**Subject:** FW: Wilkin Square, Clitheroe

**Subject:** Wilkin Square, Clitheroe

In respect of the application and reading the previous highway comments in conjunction with the Transport Statement supplied by DTPC, I would make the following comments

Proposed Site Plan

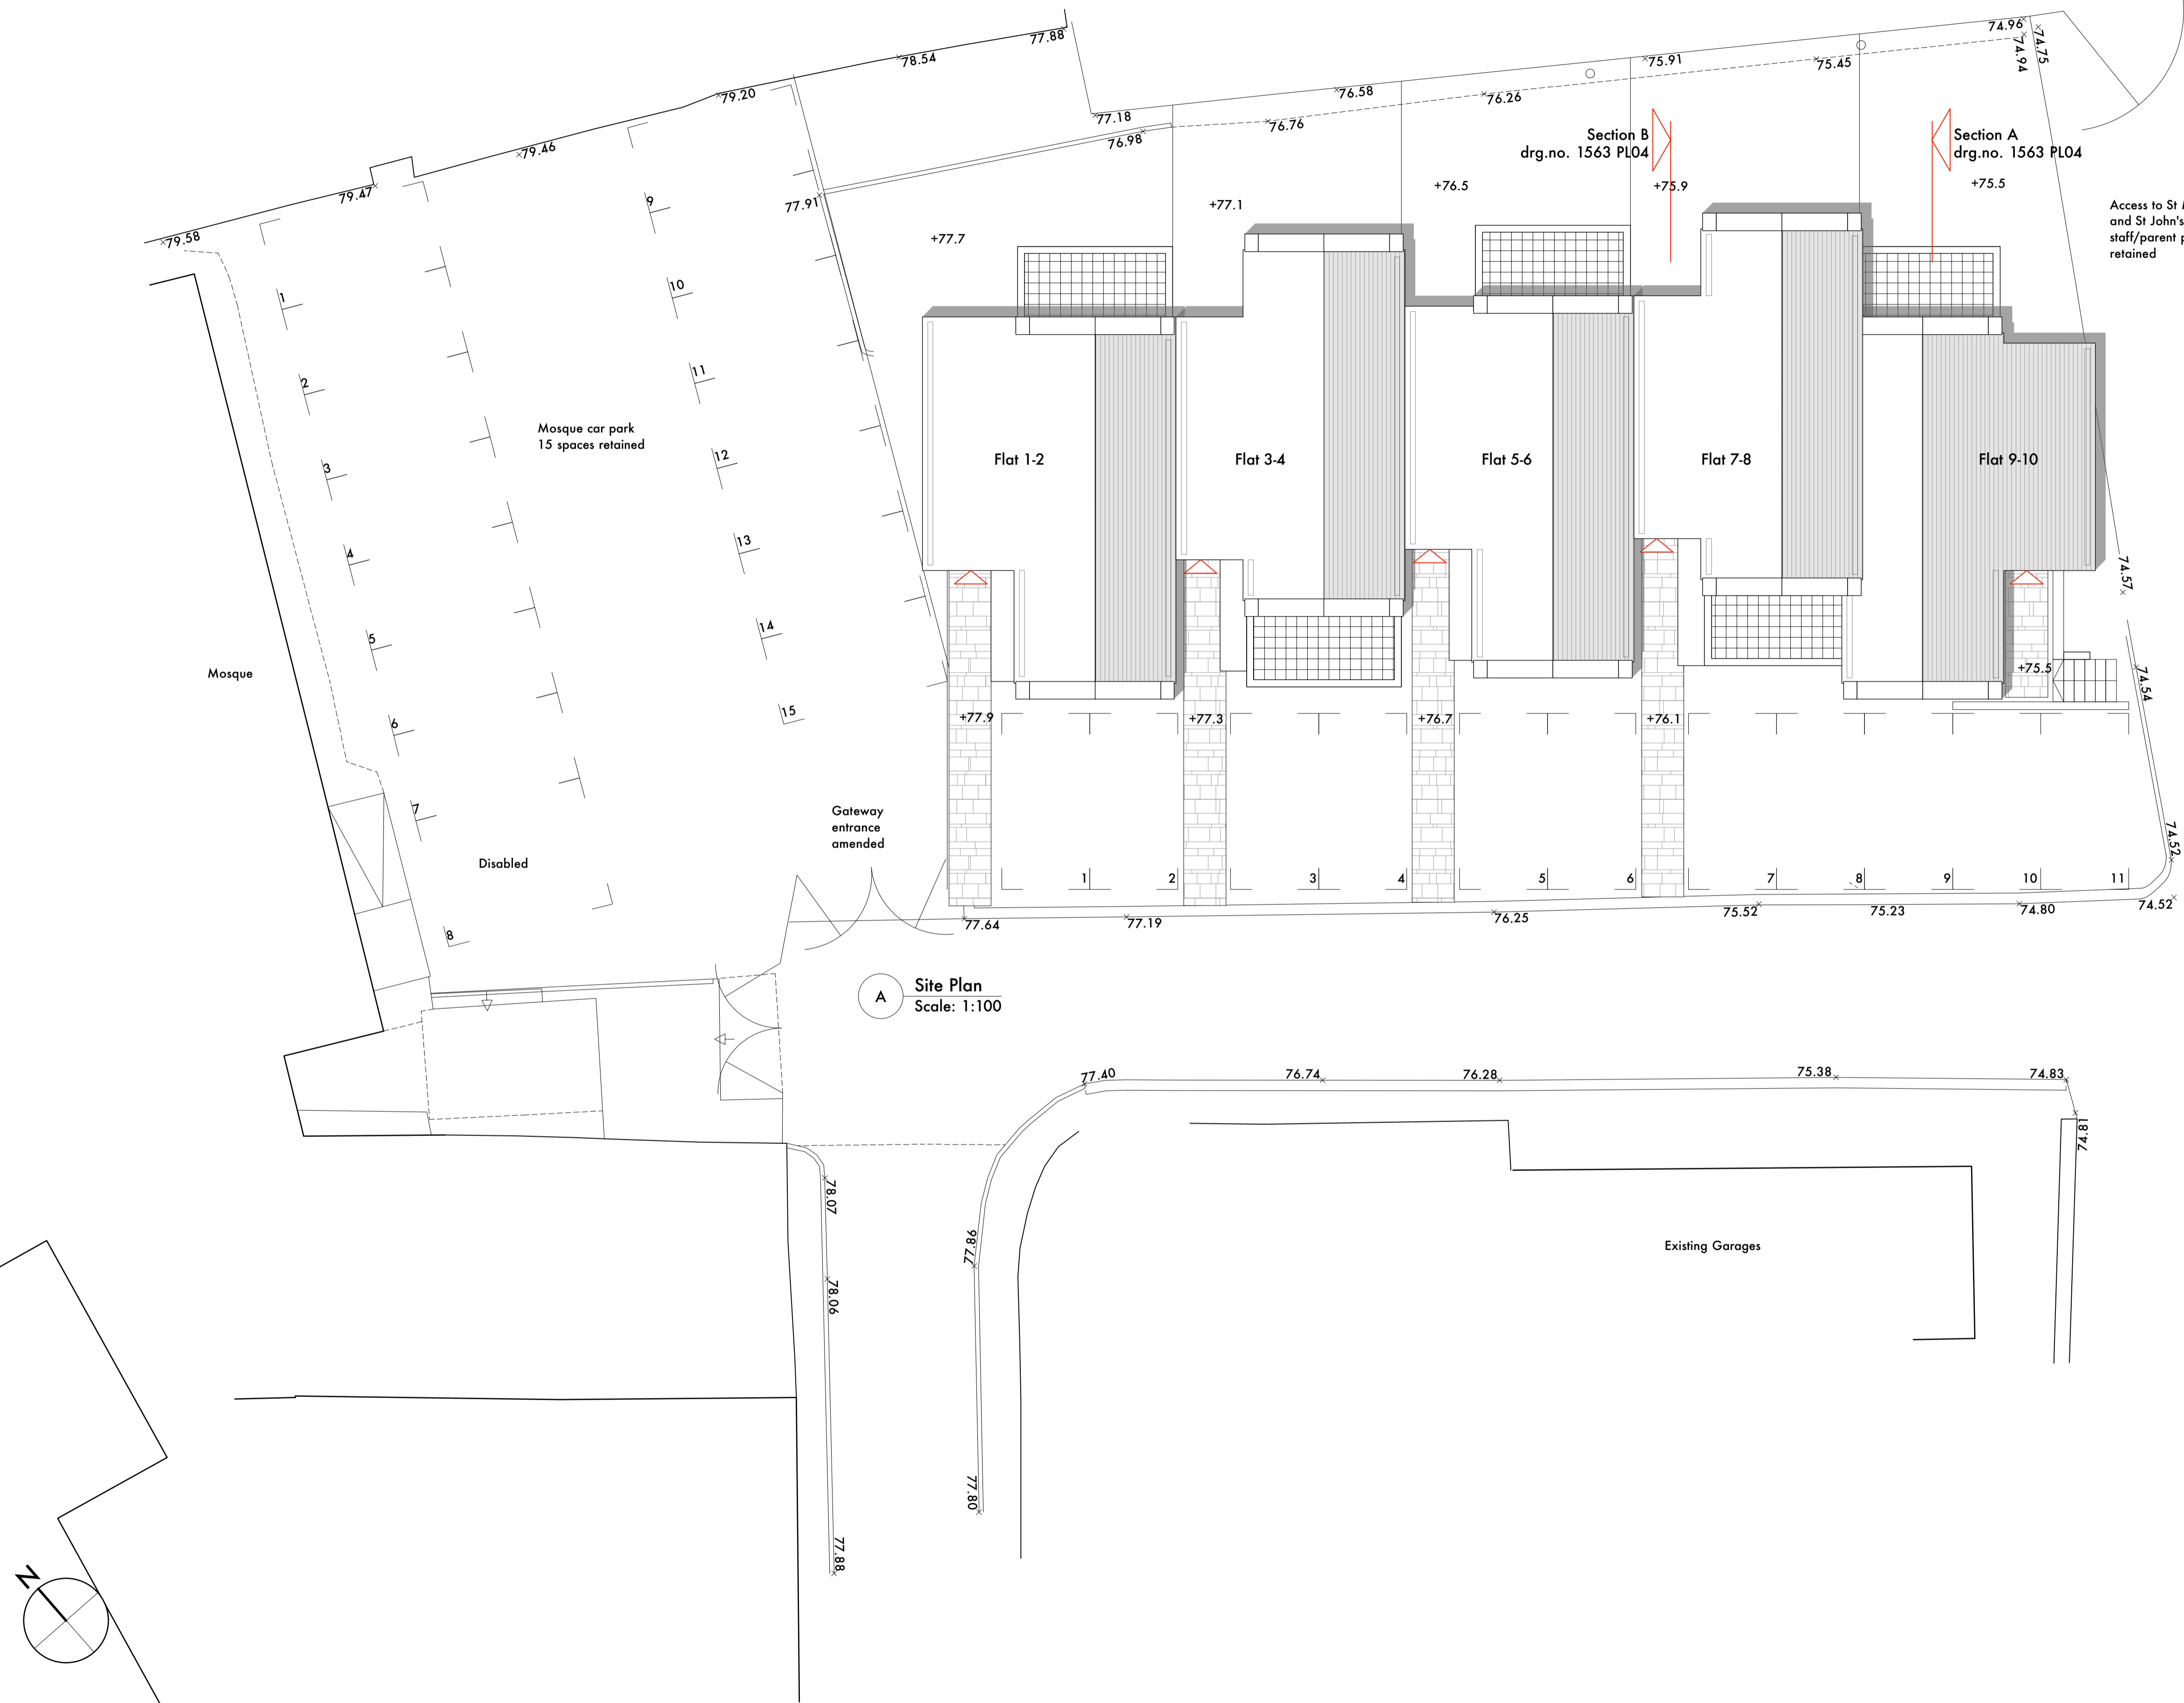
- b) The plan on the website is not printing to scale being slightly out however it would appear that the reversing space onto Wilkin Square is substandard (measuring slightly less than 5m – it should be 6) This could be rectified by setting back the buildings and increasing the length of the forecourts. There is also the possibility of the development boundaries encroaching into public highway which would not be permitted

Subject to a revised plan showing proposals to address the issues stated in 1b above and the inclusion of the suggested planning conditions in the previous response dated 15<sup>th</sup> May 2017, with the exception of Condition 3 the proposed development would be acceptable.
